Rezoning Transportation Analysis

Petition Number: 2021-079

From: Brandon Brezeale, PE

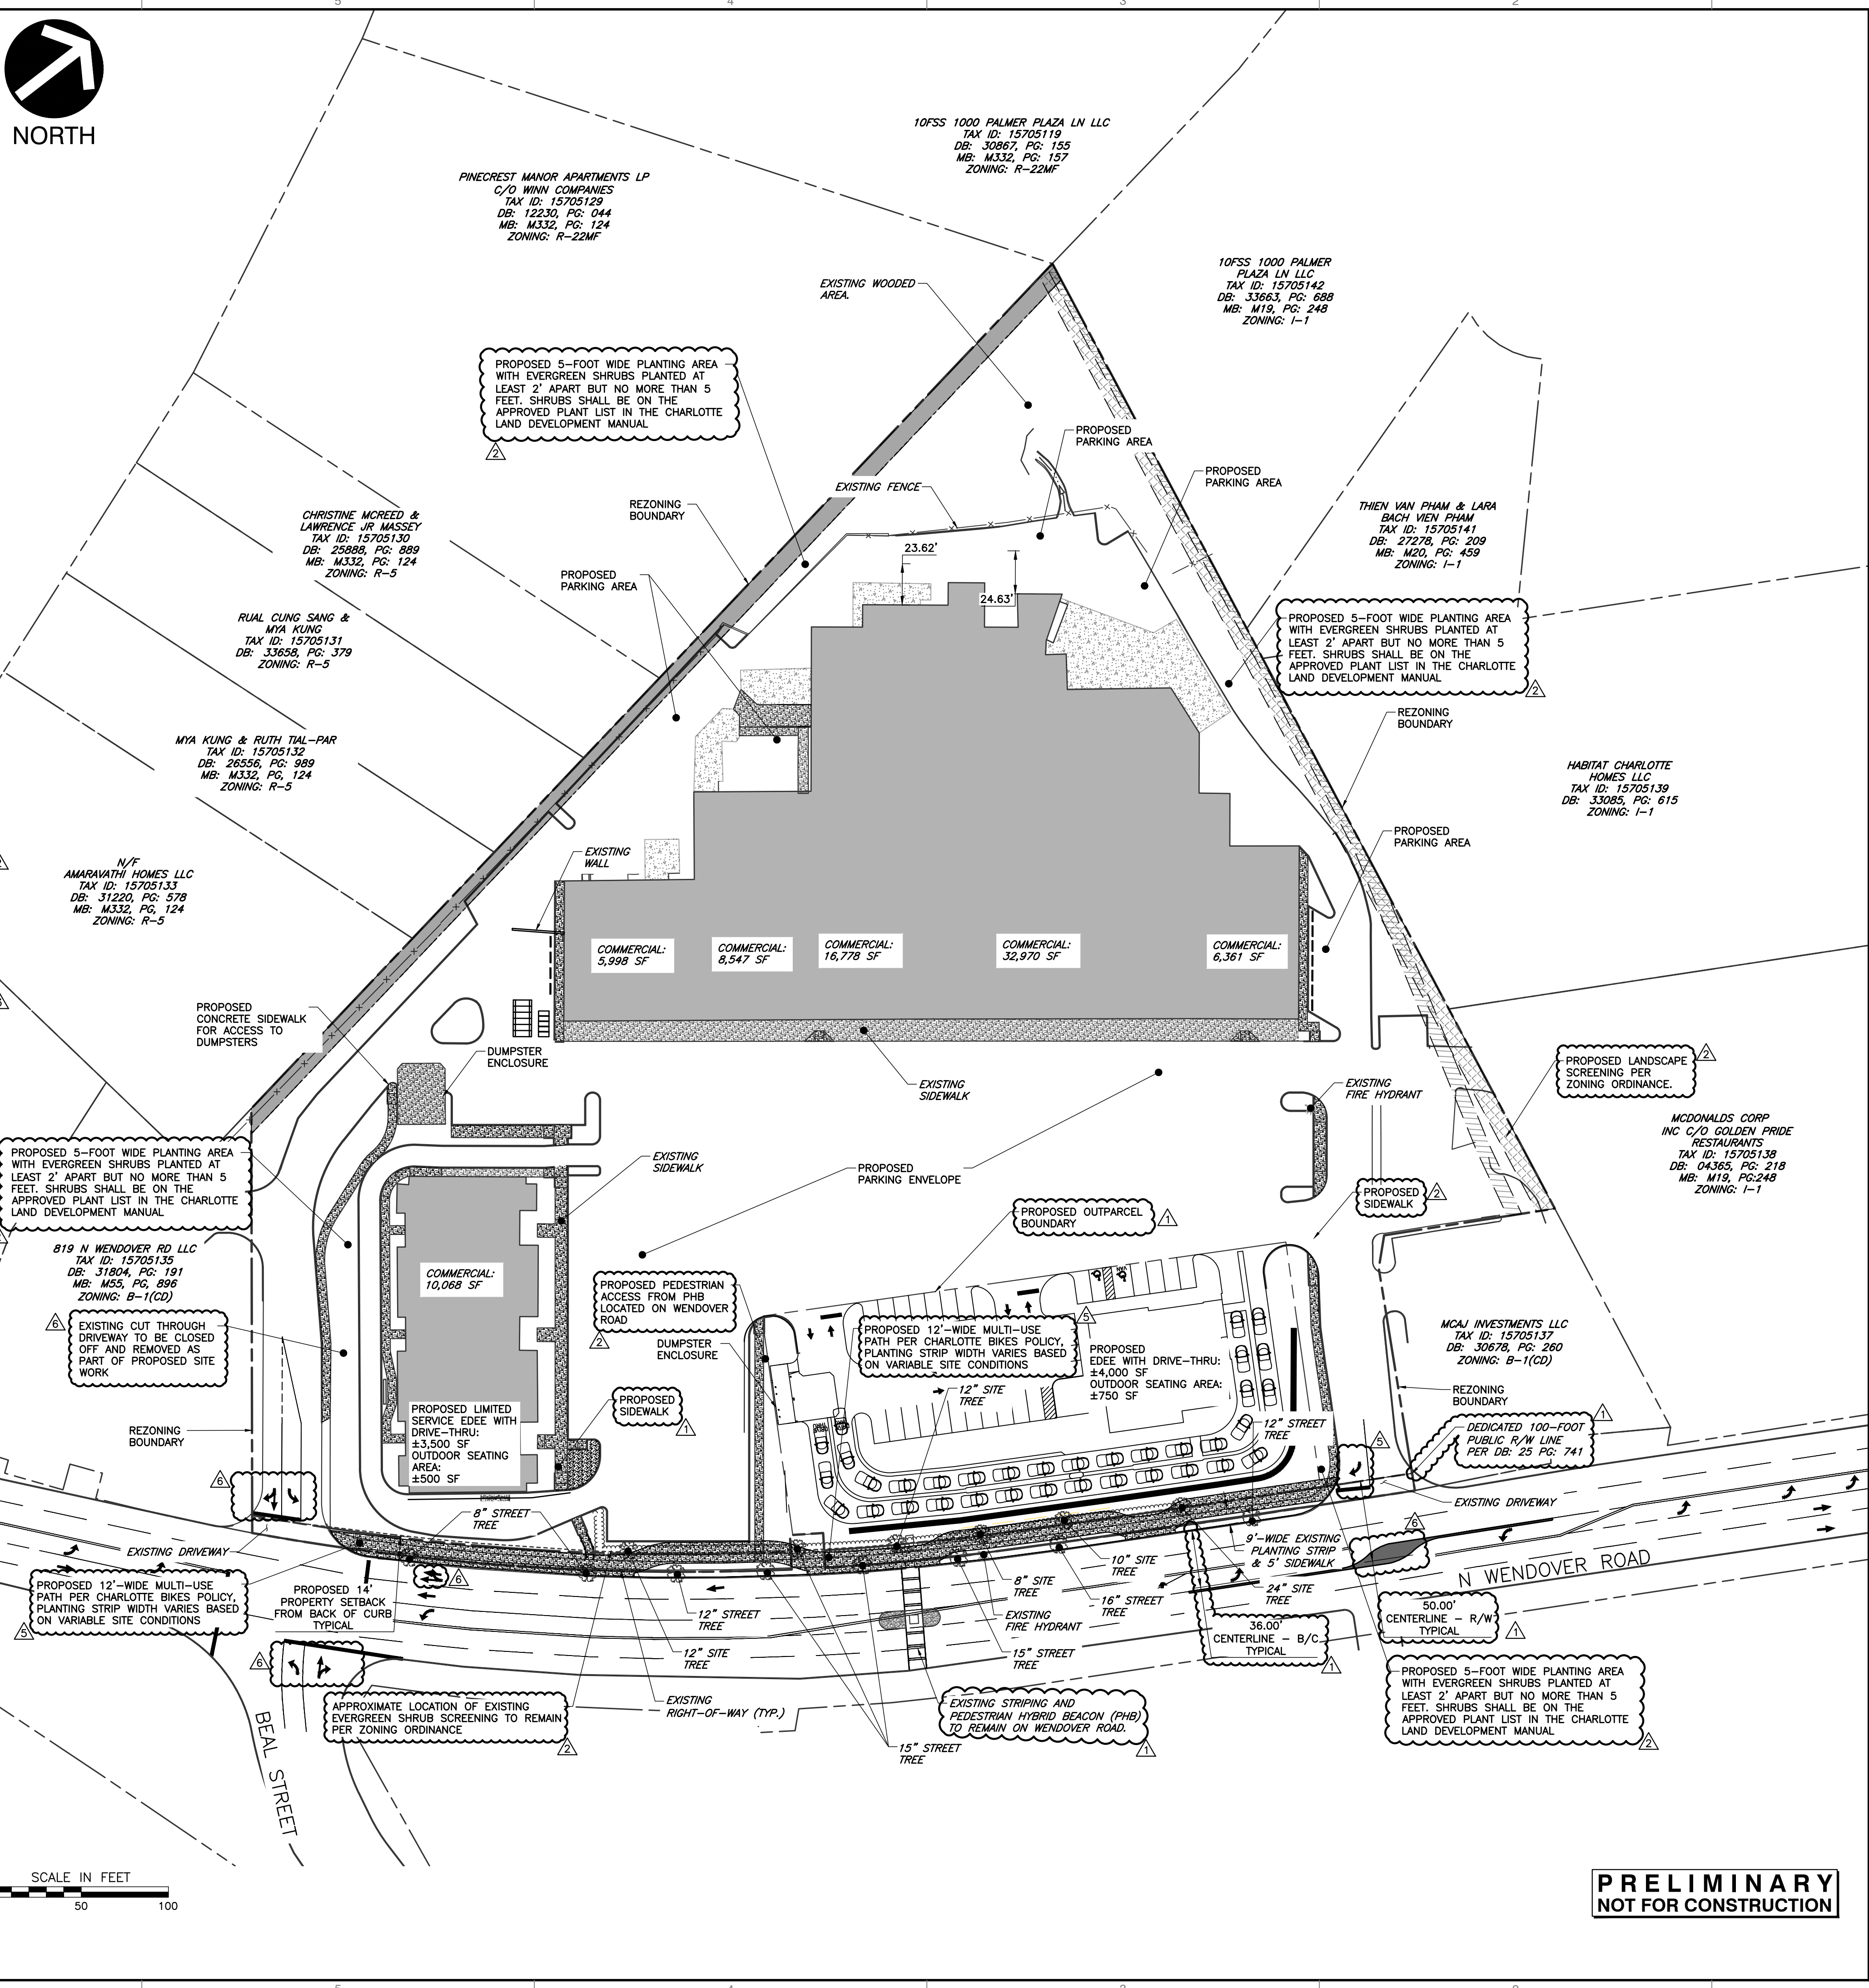
3. **NEW COMMENT (03-16-2022; recommendations based on TIS recommendations)**

Site plan revisions are needed to commit to the installation of a raised concrete median at Access 2 to enforce a directional crossover.
